PLACE AND GROWTH INTERNAL MEMORANDUM

Our Ref: Application Response **Your Ref:** 20/02060/F

APPLICATION FOR PLANNING PERMISSION PLANNING POLICY CONSULTATION RESPONSE

Planning Application No.	20/02060/F
Address / Location	The Stables, Main Street, Great Bourton, Cropredy, OX17 1QU
Proposal	Change of use of land to a mixed use for the keeping of horses (existing) and as a residential caravan site for 4no gypsy families. Each with two caravans (including no more than 4no static caravans / mobile homes) together with the laying of hardcore
Key Policies / Guidance	<p><u>Cherwell Local Plan 2011-2031 Part 1</u></p> <p>Policy PSD1: Presumption in Favour of Sustainable Development Policy BSC6: Travelling Communities Policy ESD10: Protection and Enhancement of Biodiversity and the Natural Environment Policy ESD13: Local Landscape Protection and Enhancement Policy ESD15: The Character of the Built and Historic Environment Policy Villages 1: Village Categorisation</p> <p><u>Cherwell Local Plan 1996 (saved policies)</u></p> <p>Policy C8: Sporadic development in the open countryside Policy C28: Layout, design and external appearance of new development</p>

# SITE LAYOUT PLAN

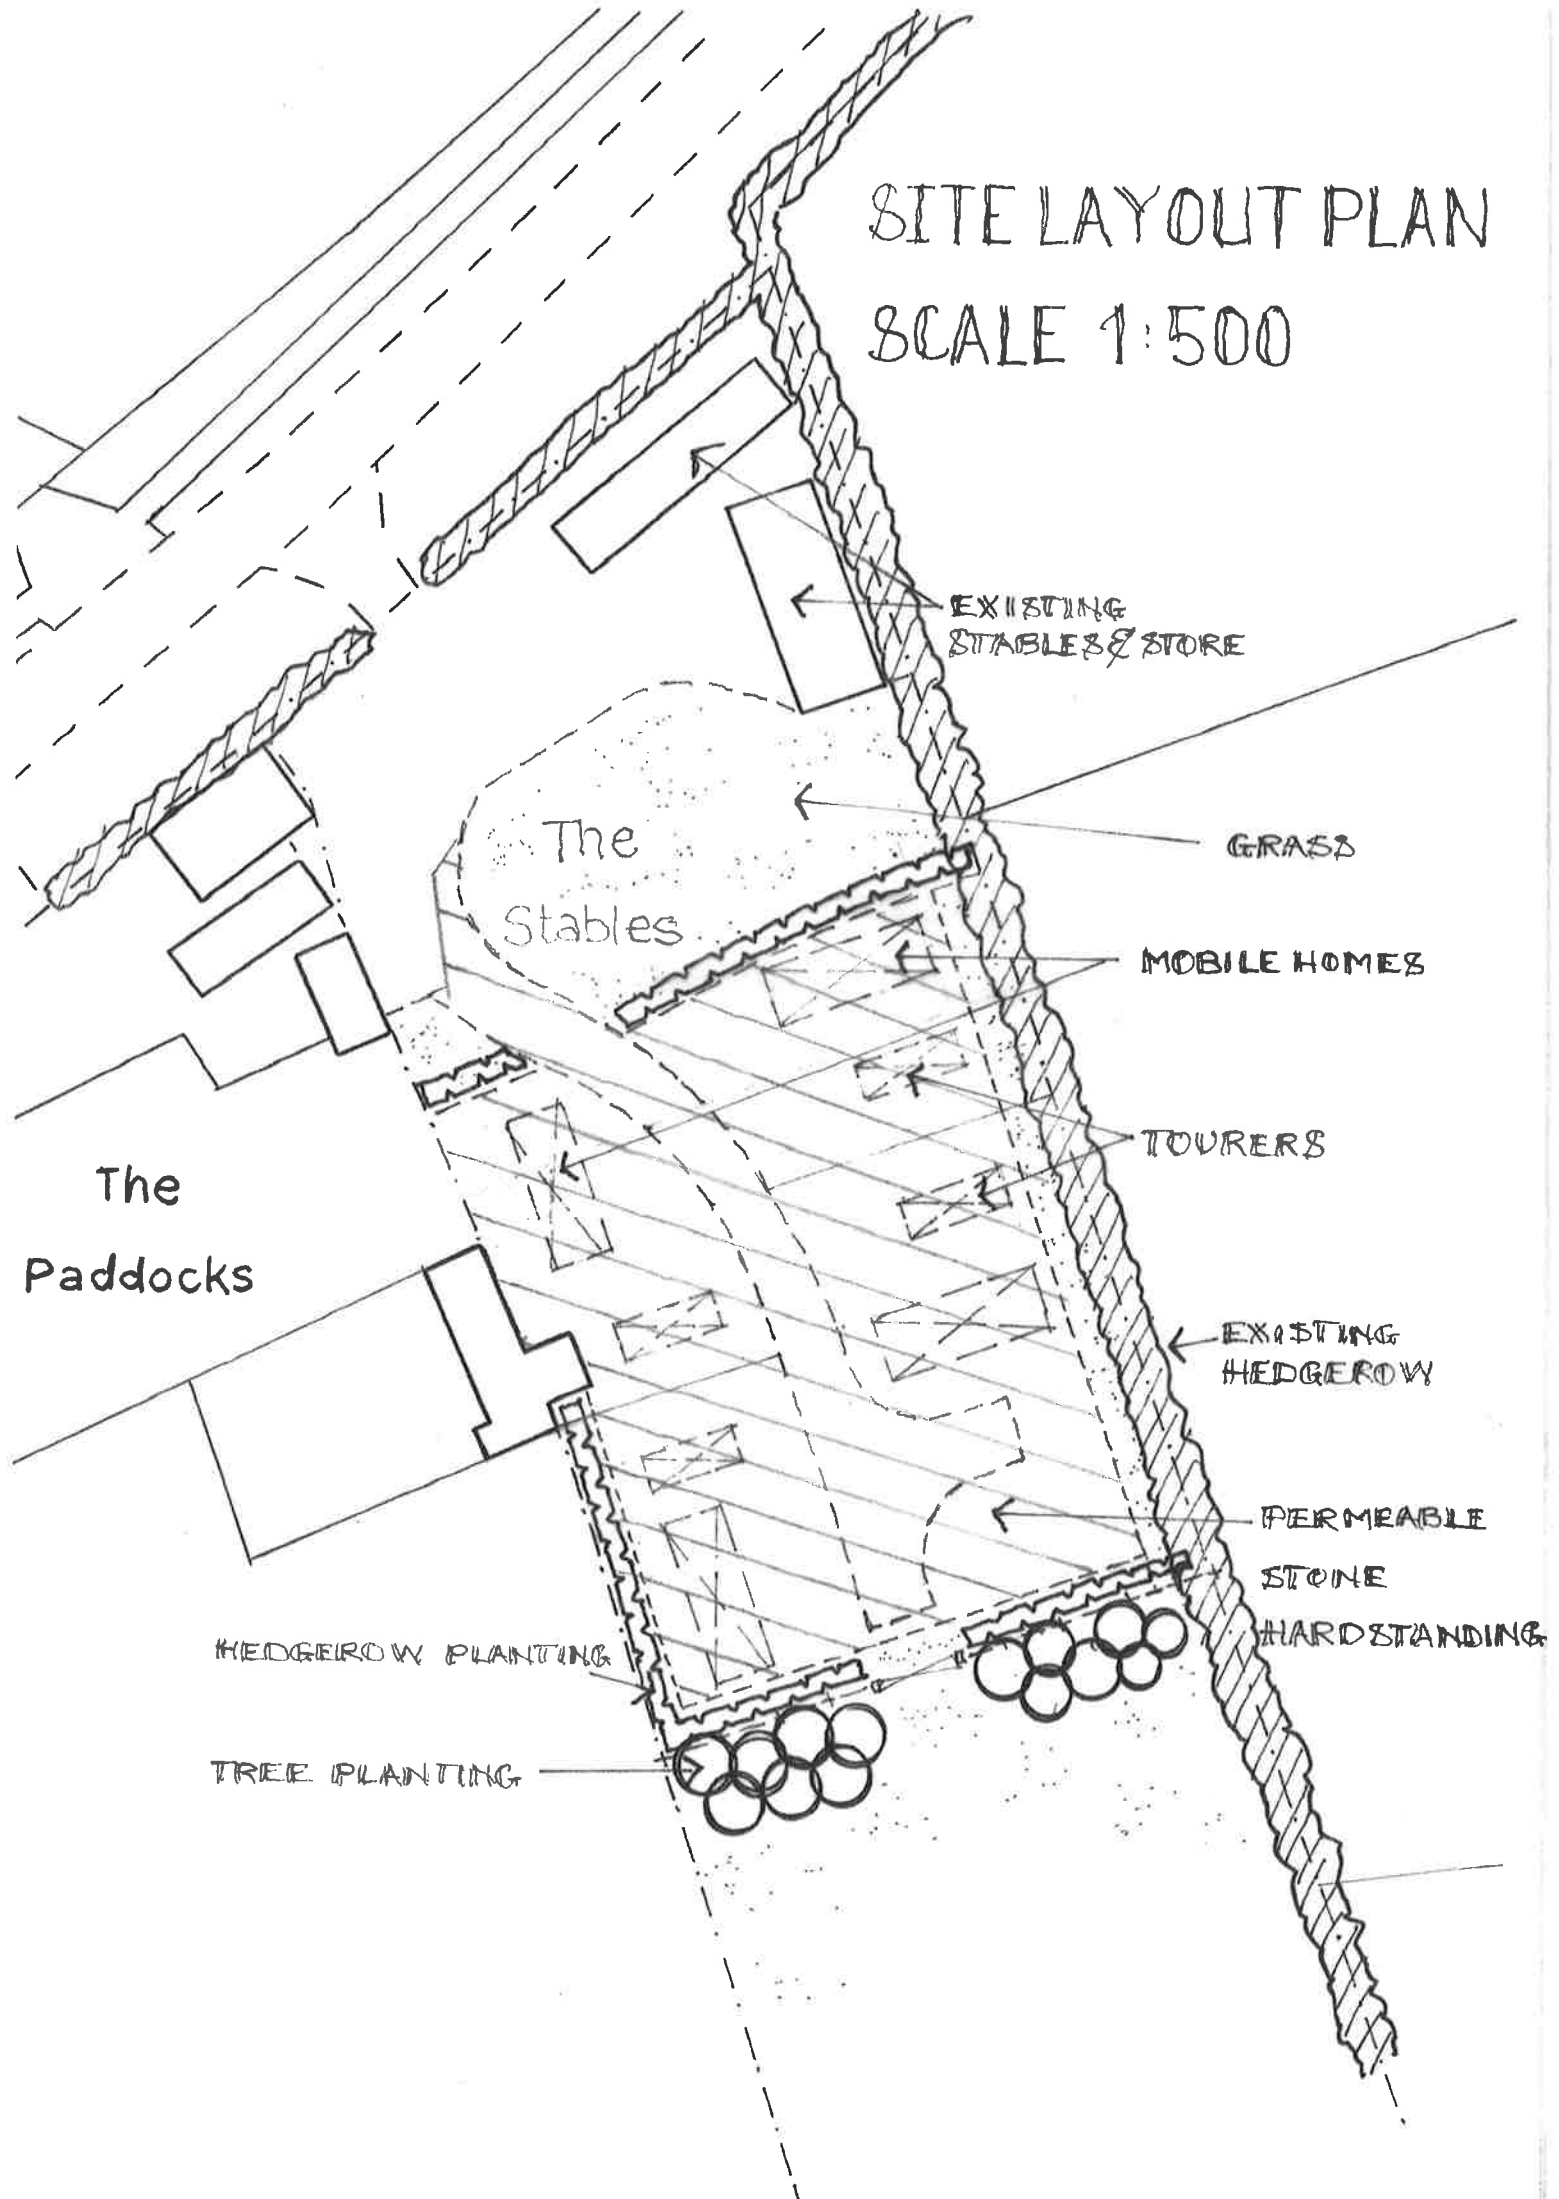
<p>Policy Recommendation</p>	<p>There is currently a sufficient supply of gypsy and traveller pitches based on the most up to date evidence on need therefore there is no pressing need for additional land to be released at this time. Detailed issues to be considered include whether a satisfactory living environment could be secured and potential impacts on biodiversity and visual impact and effect on landscape character.</p>
